From: Stuart Corbey
Sent: 31 May 2019 14:52
To: 'Natalie McKellar'
Cc: Daniel Vick; Planning.Responses
Subject: RE: Response To Application Number Y/22/19/PL at Garage Premises Main Road Yapton BN18 0EA

From: Stuart Corbey [<mailto:Stuart.Corbey@arun.gov.uk>]
Sent: 06 April 2019 11:21
To: Natalie McKellar
Subject: FW: Response To Application Number Y/22/19/PL at Garage Premises Main Road Yapton BN18 0EA

PROJECT	CLIENT	DATE	DRAWN
Reptune Garage site Main Road YAPTON	P Mountford	Feb 2019	pm
DRAWING	SCALE	DRAWING NO	REV
Block plans as existing and proposed	1:500@A3	1801/07

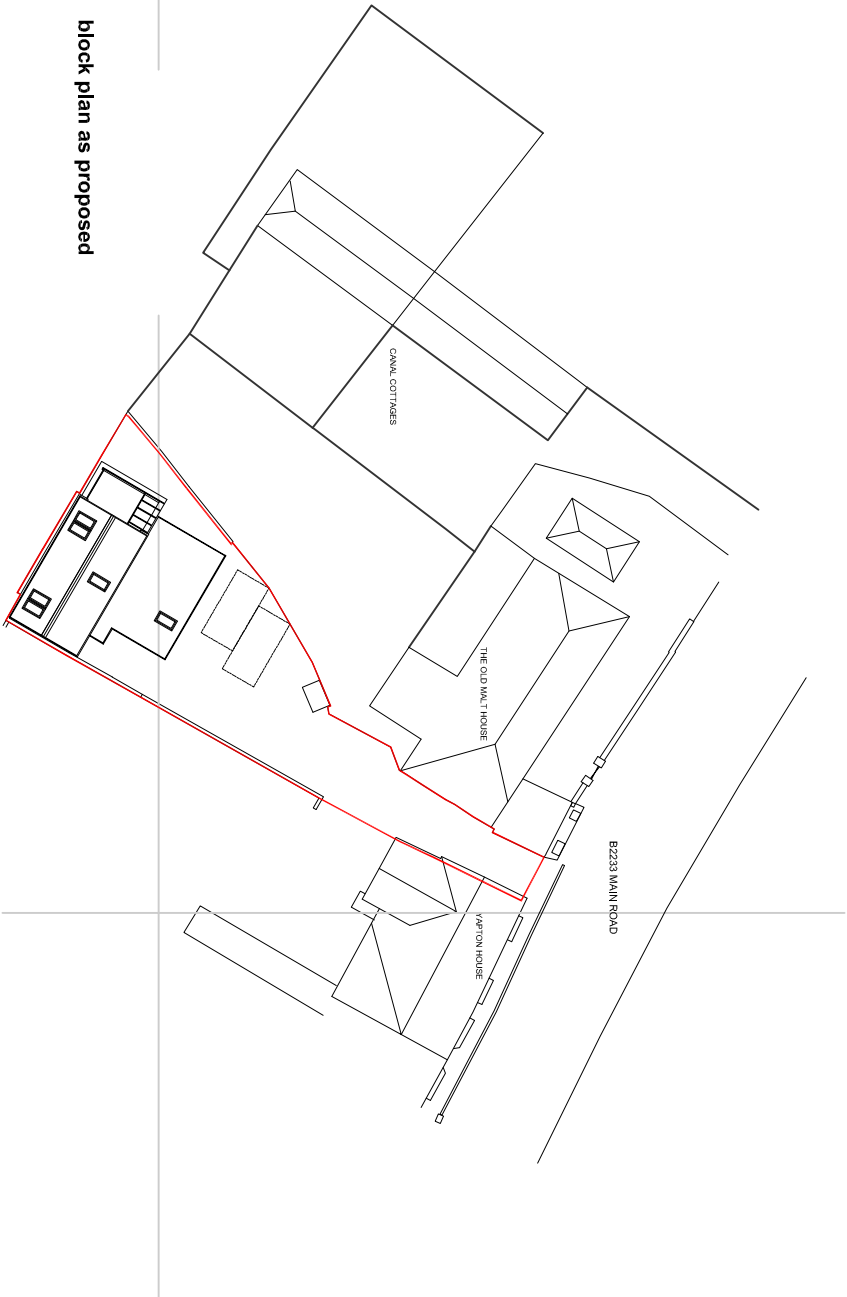
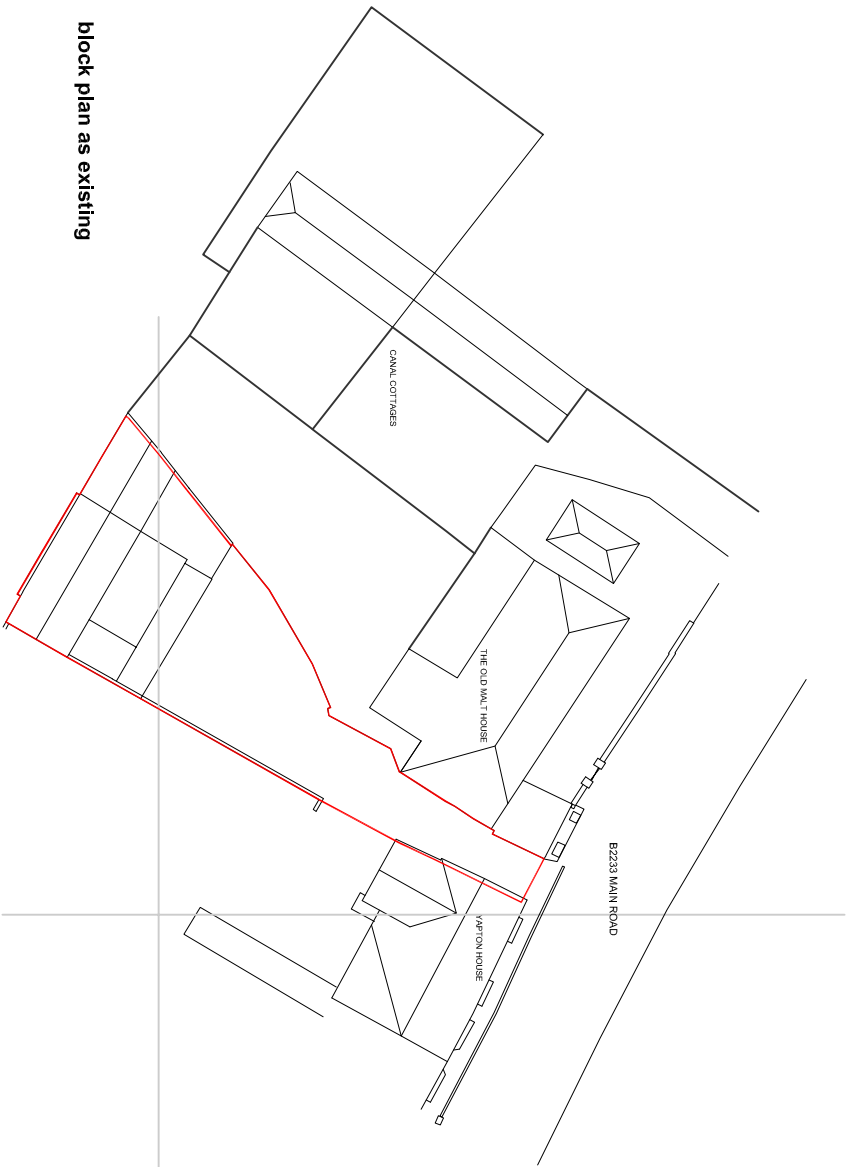
The revised parking arrangement does not appear workable. Whilst it is appreciated that the Design &

Access Statement refers to these spaces as being extra-wide to allow for reduced aisle width they have been marked out at 2.4m by 4.8m and the staggered arrangement reduces the available width for turning further. Manual for Streets 2 paragraph 11.1.9 states that 6 metre clear space should be provided for such spaces. Widening and slight relocation of the spaces may improve the manoeuvre to ensure a car can easily turn on site in order to exit on to the public highway in a forward gear. The applicant is advised to demonstrate the workability of any amended parking spaces through swept path tracking.

Further to your email below I attach additional drawing: Reptune-TRK-001 showing swept paths for large cars accessing and exiting both parking spaces whilst the other is in use. This has been achieved by increasing the distance between spaces, as shown on the attached amended plans 1801 02A and 07A. I would be grateful if you could confirm this addresses the concerns raised by the highway engineer.
